Subject: AU-25-00004 Wetzel - Notice of Application

Please review the following Boundary Line Adjustment: AU-25-00004 Wetzel. Any comments need to be received by **5 PM on March 5th, 2025**.

AU-25-00004 Wetzel

AU-25-00004 Wetzel Critical Areas

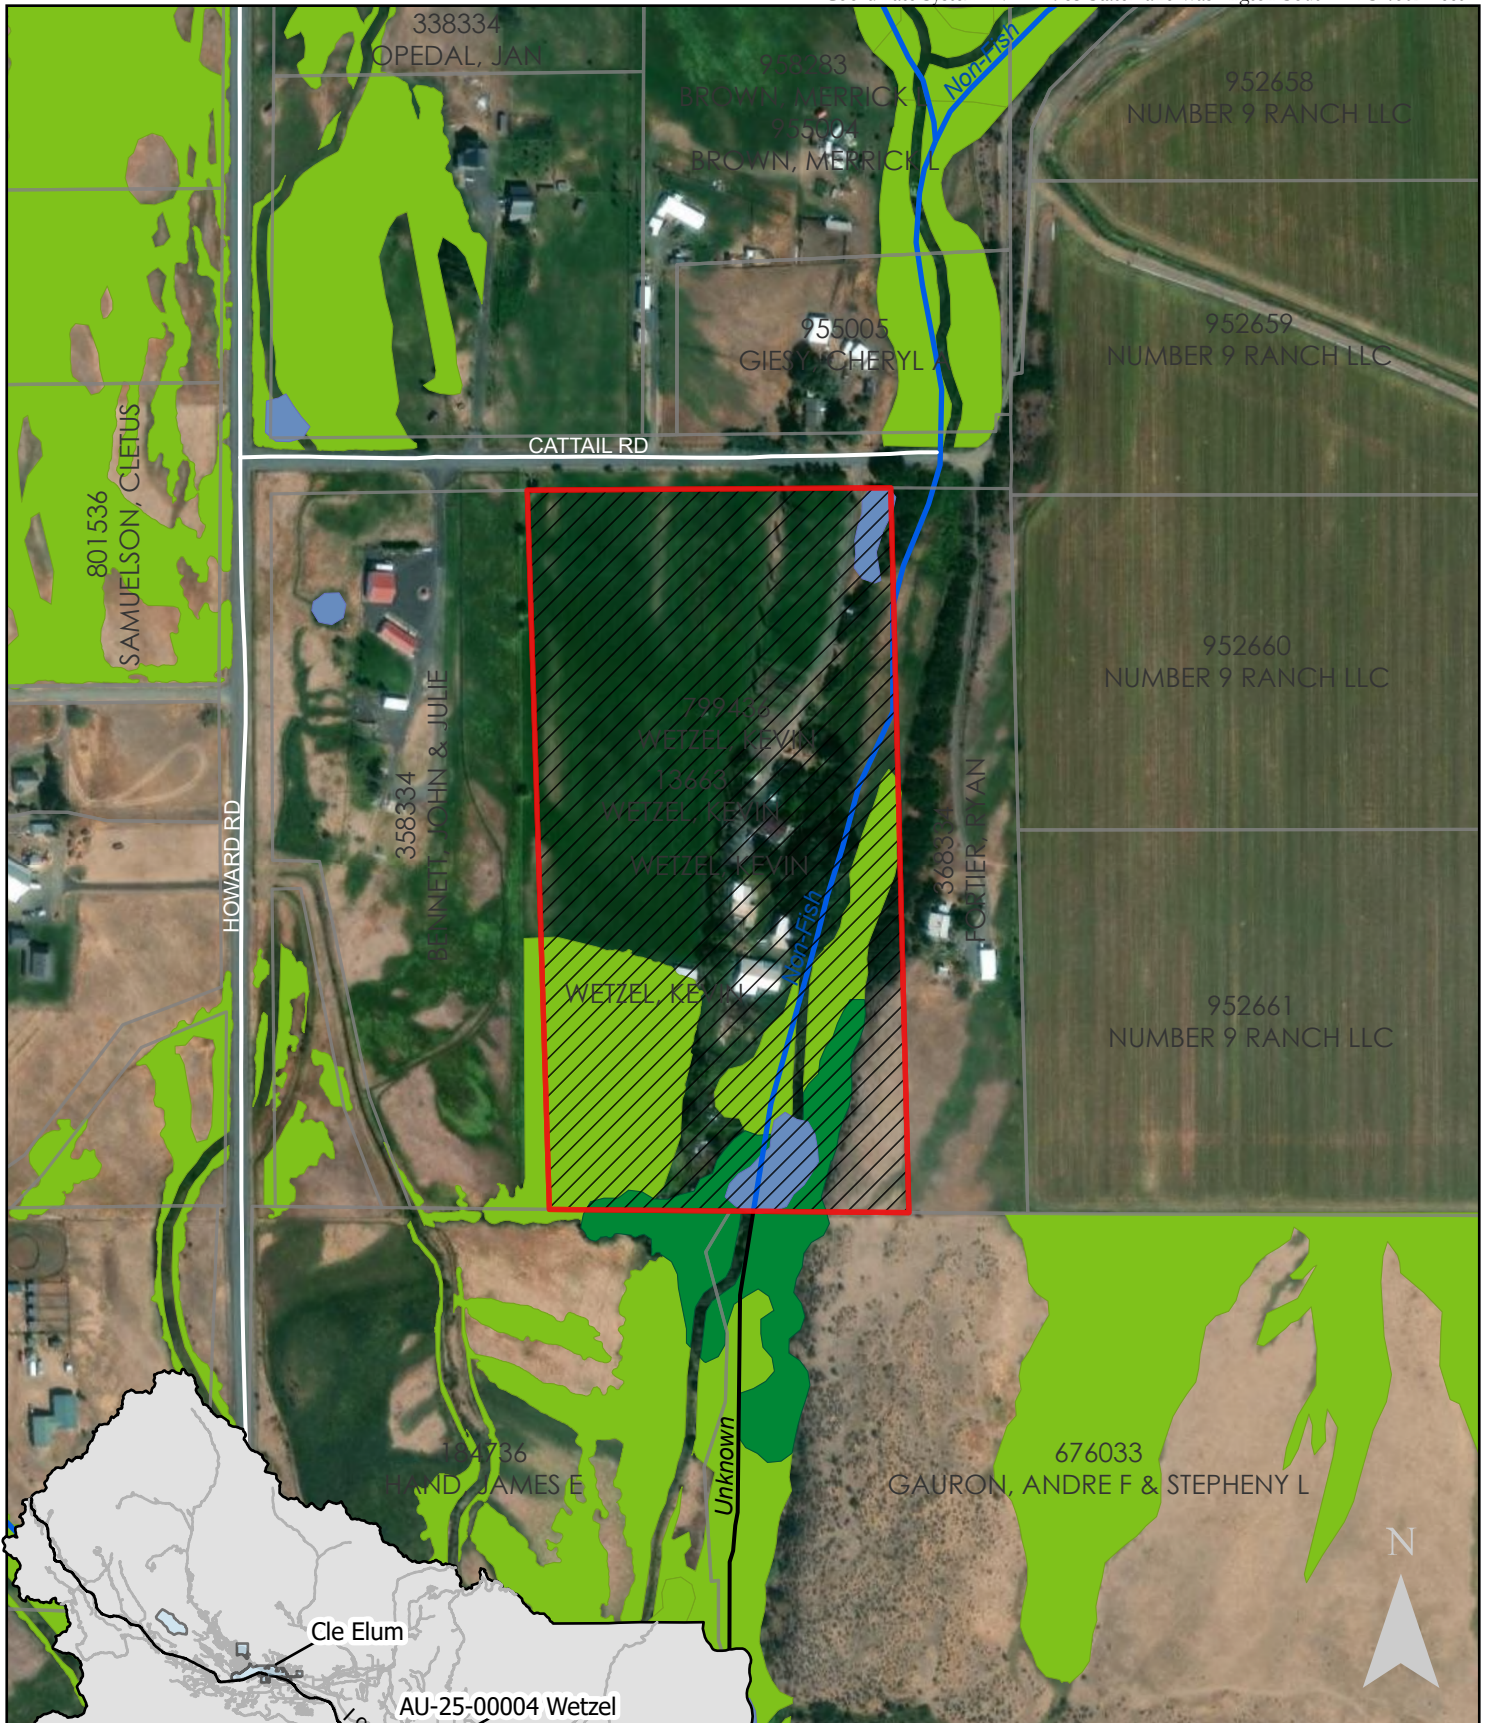
The stream located on the property is a tributary to Dry Creek, a fish-bearing tributary to the Yakima River. There are also several mapped wetlands along the stream corridor and southern end of the property. We recommend any proposed development near the stream and wetlands be evaluated for consistency with Kittitas County's Critical Areas Ordinance. Proposed work in or near the stream will require a Hydraulic Project Approval from WDFW.

We appreciate that as currently shown on the site plan, the new development will be outside of the stream and wetland buffers.
